1 FINAL TOWER ELEVATION  
SCALE: NOT TO SCALE

INGENU SITE NUMBER:  
**US-DEN-3002B**

BU #: 877090  
**FILL-IN/ COLORADO SPGS/  
CSP154**

EXISTING 70'-0" SELF  
SUPPORT TOWER

C-2

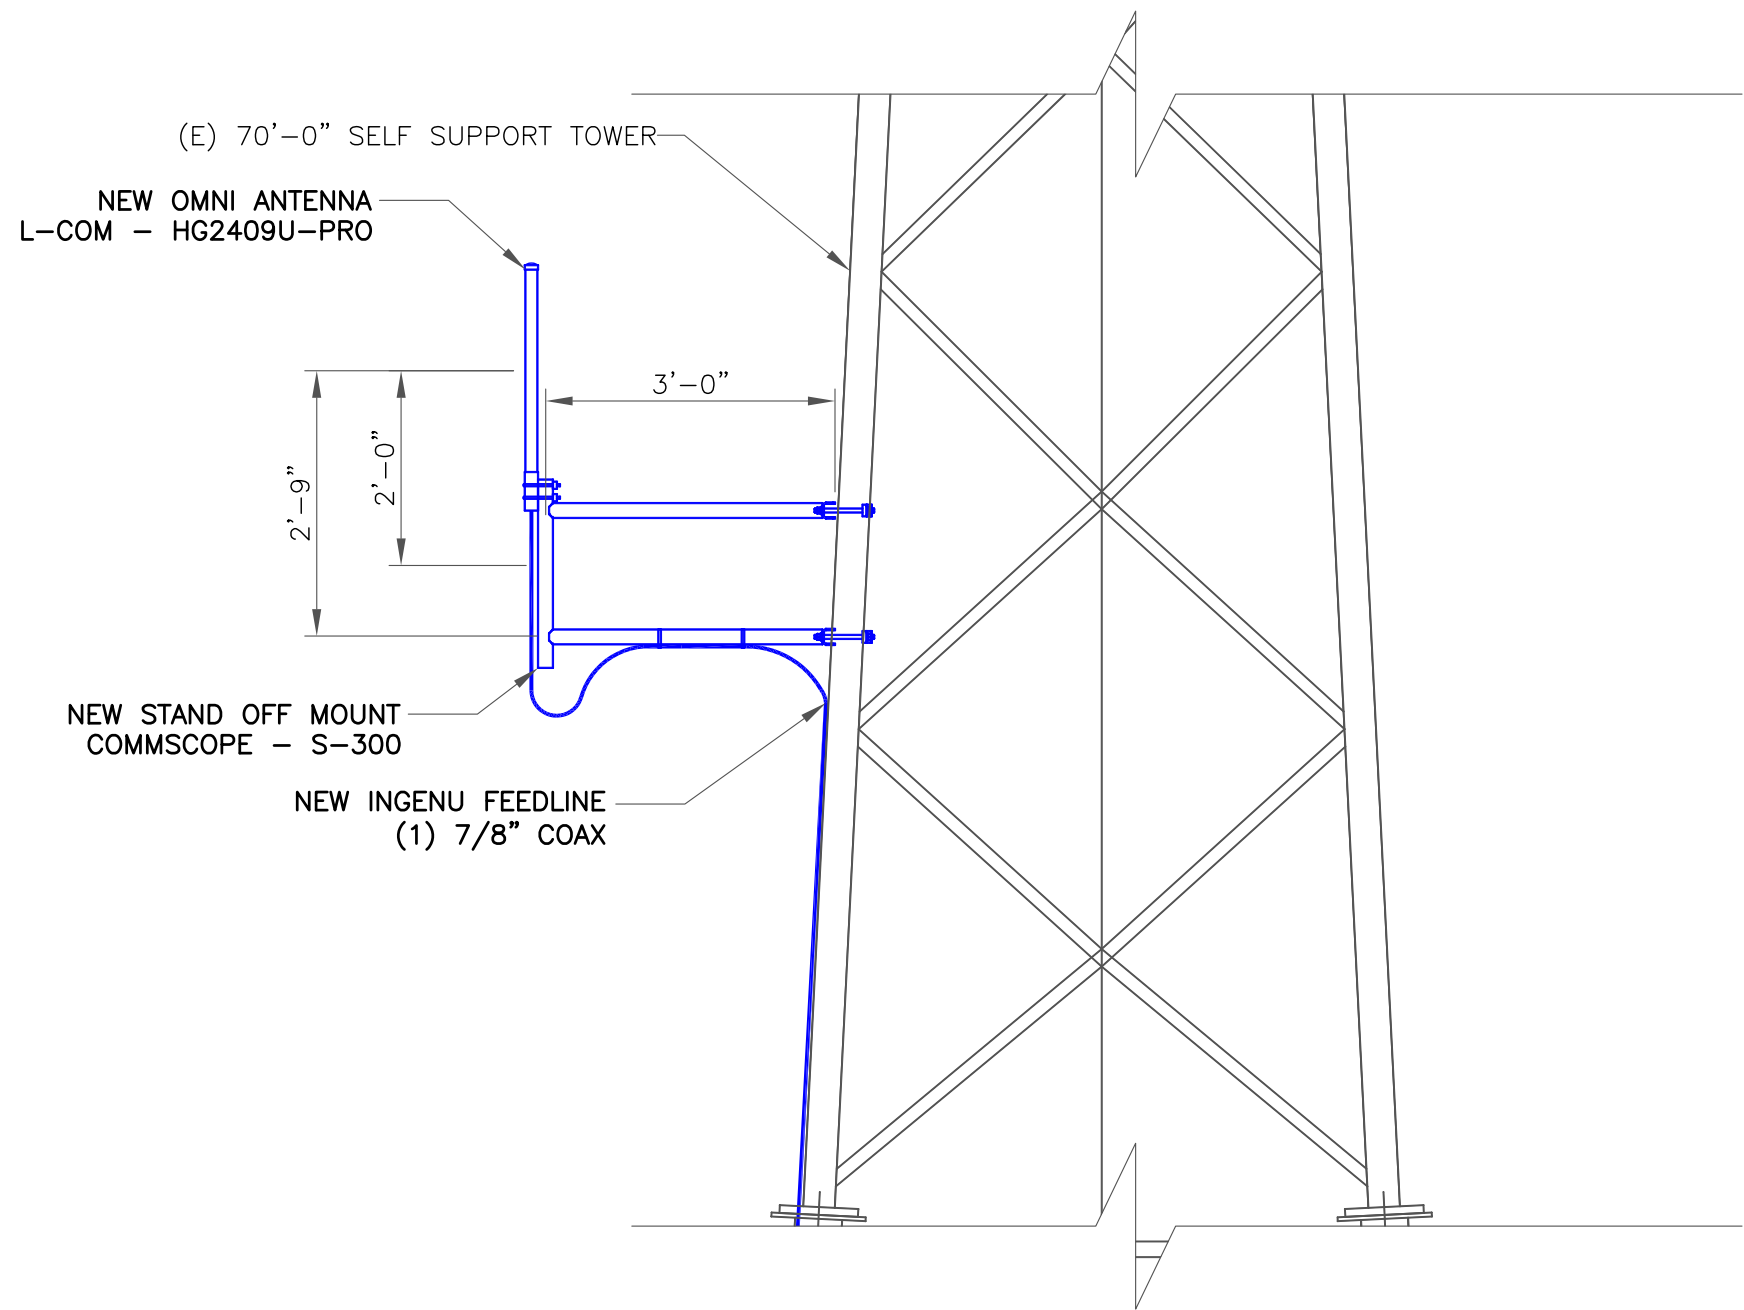
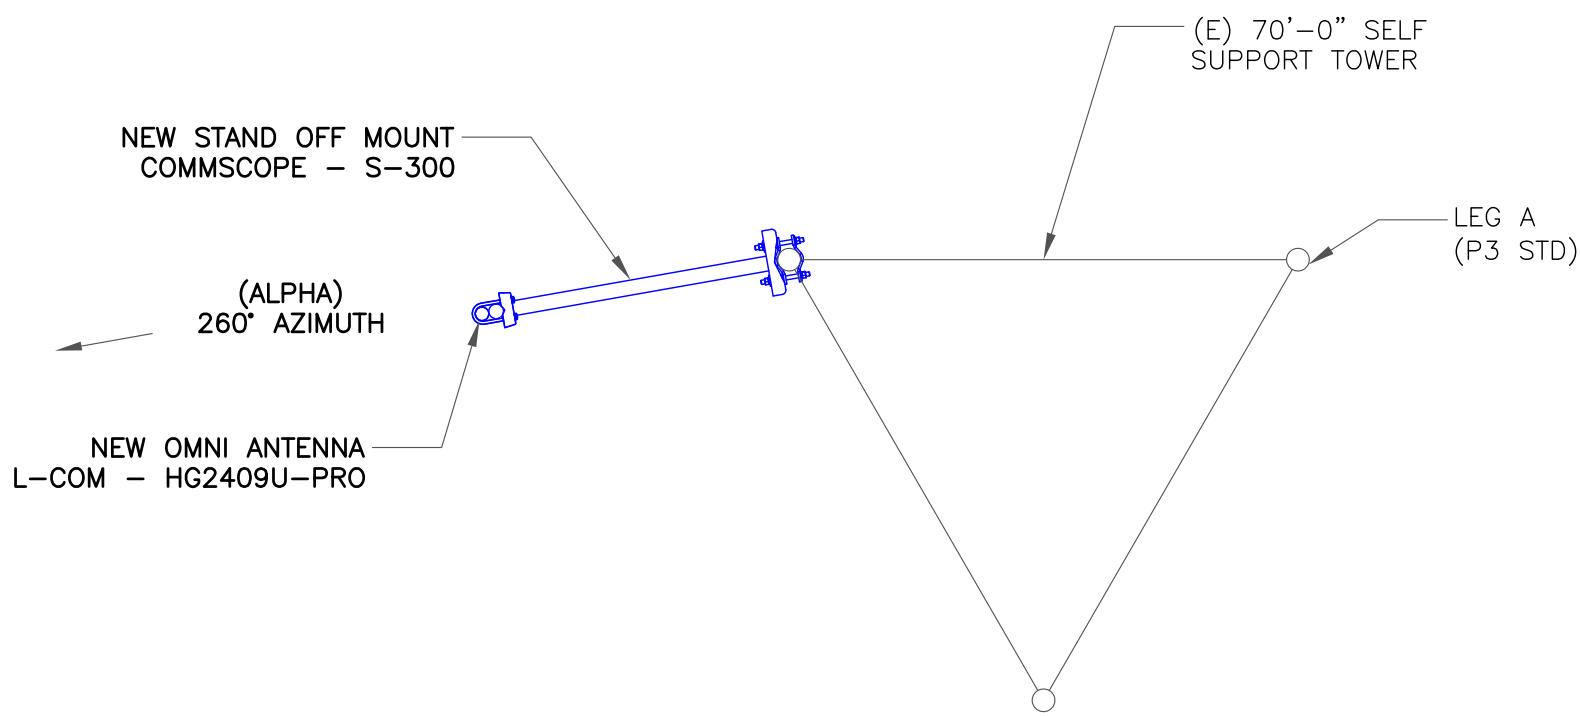
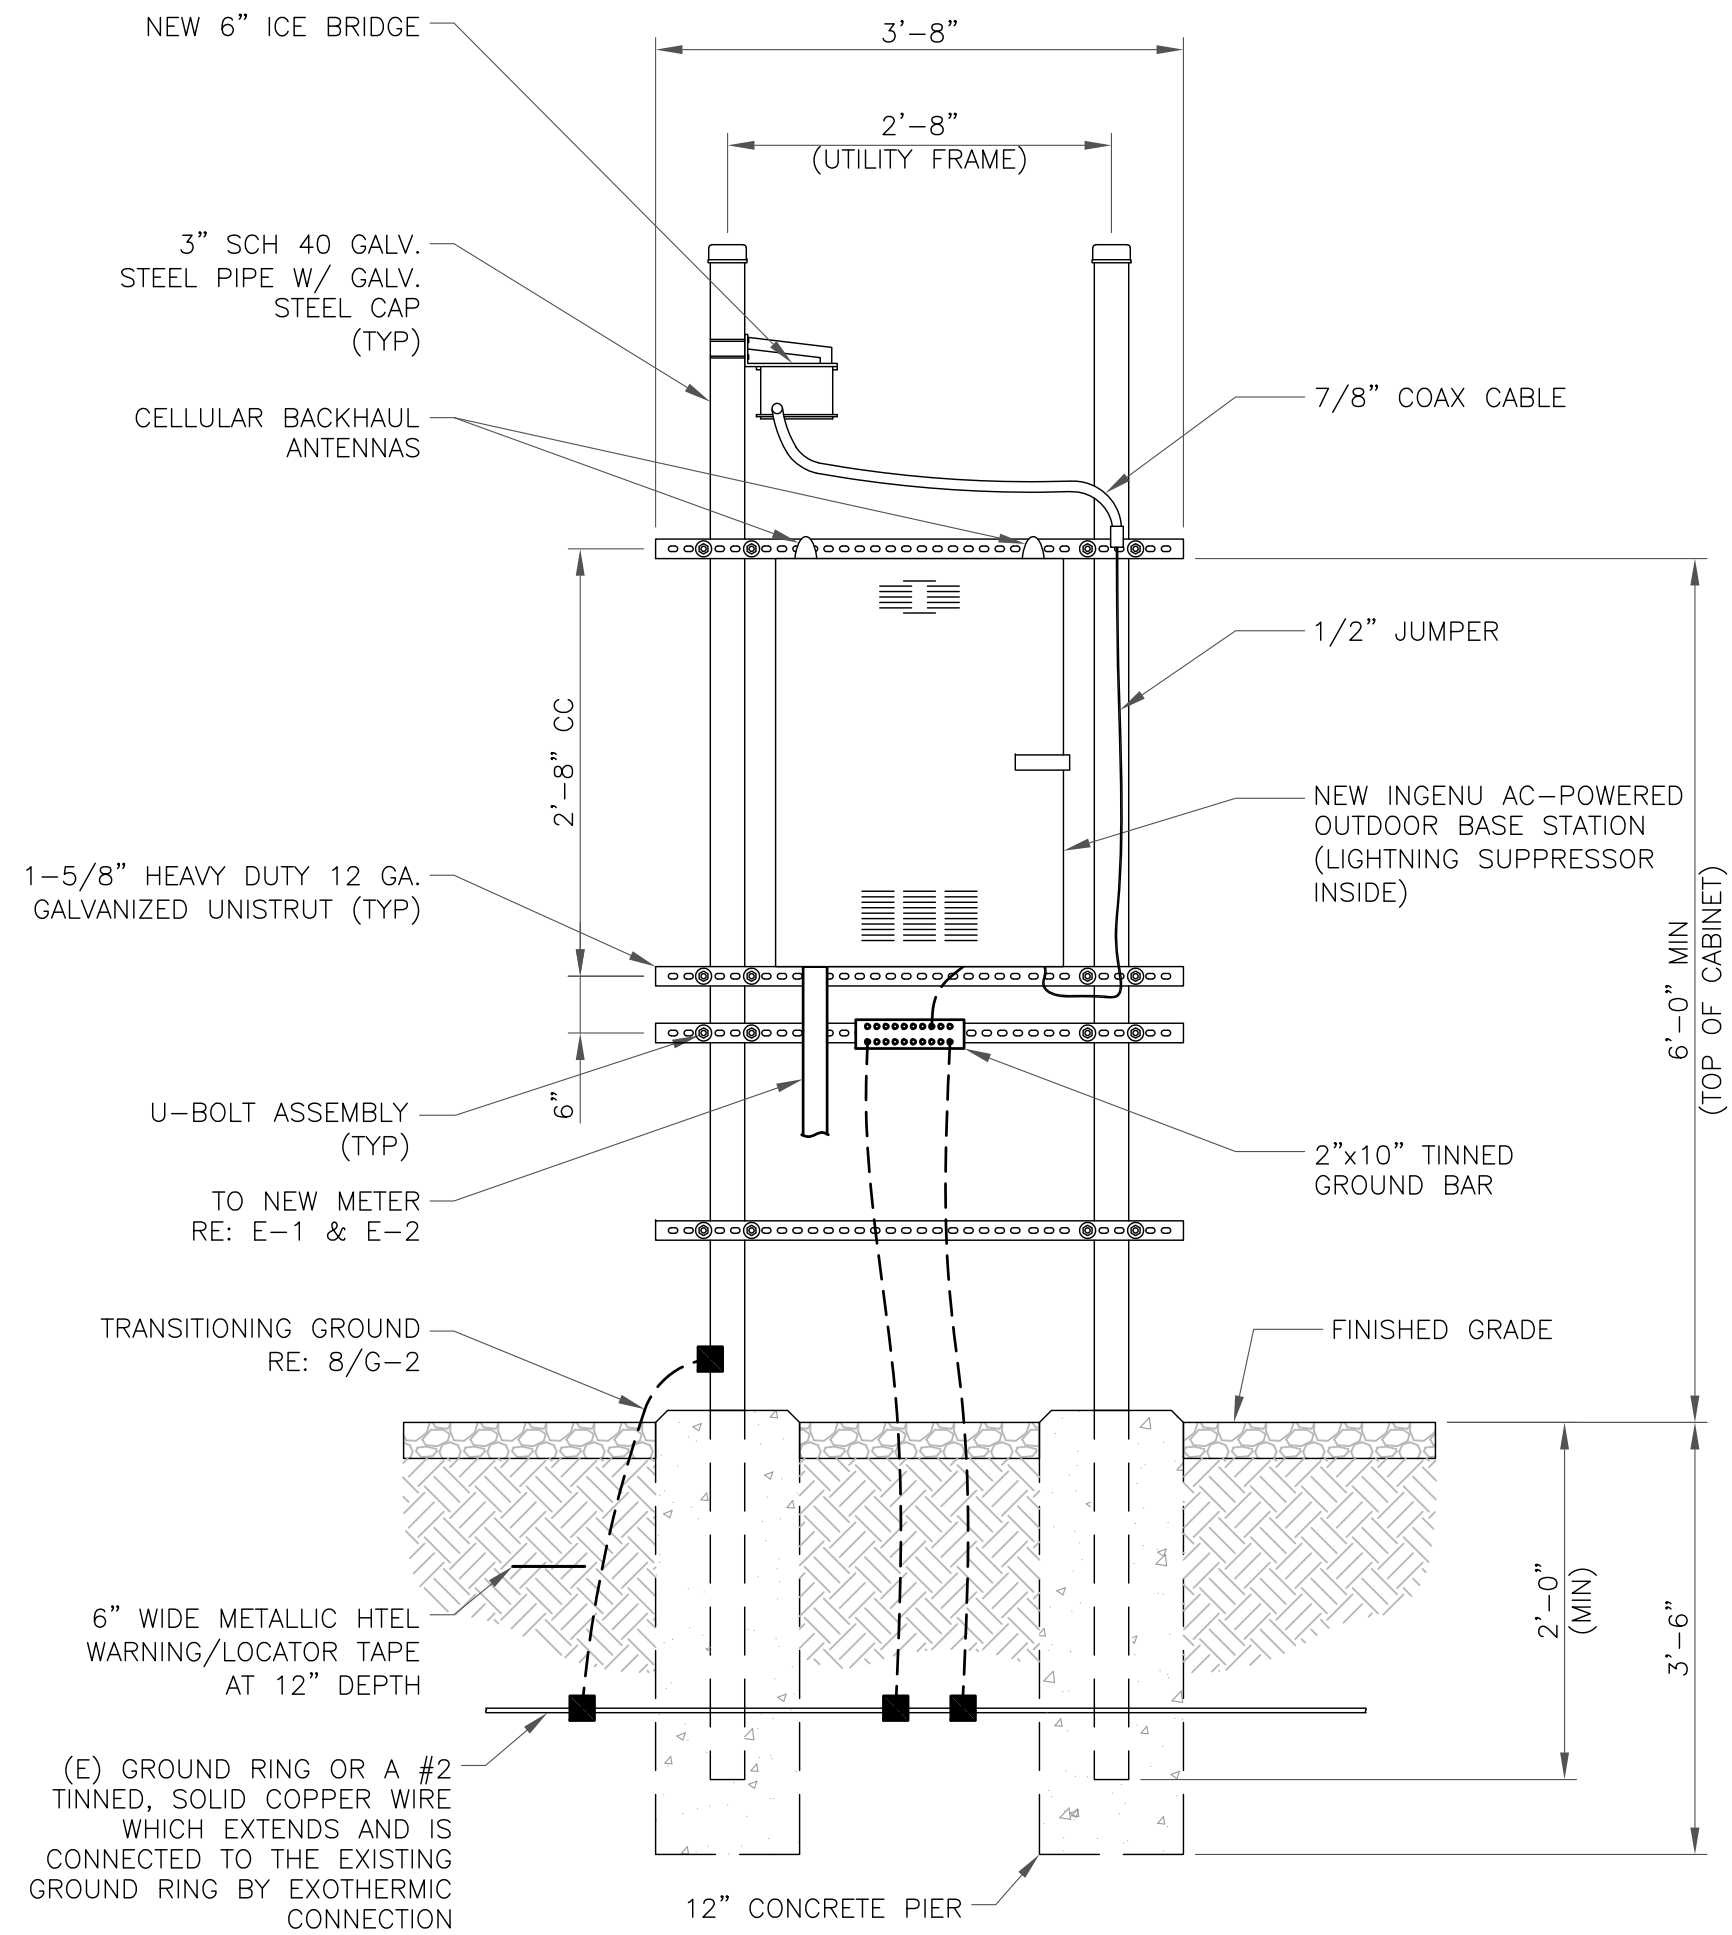
The special use approved an 80 tower (AL-08-019).

The special use approved an 80' tower (AL-08-019).
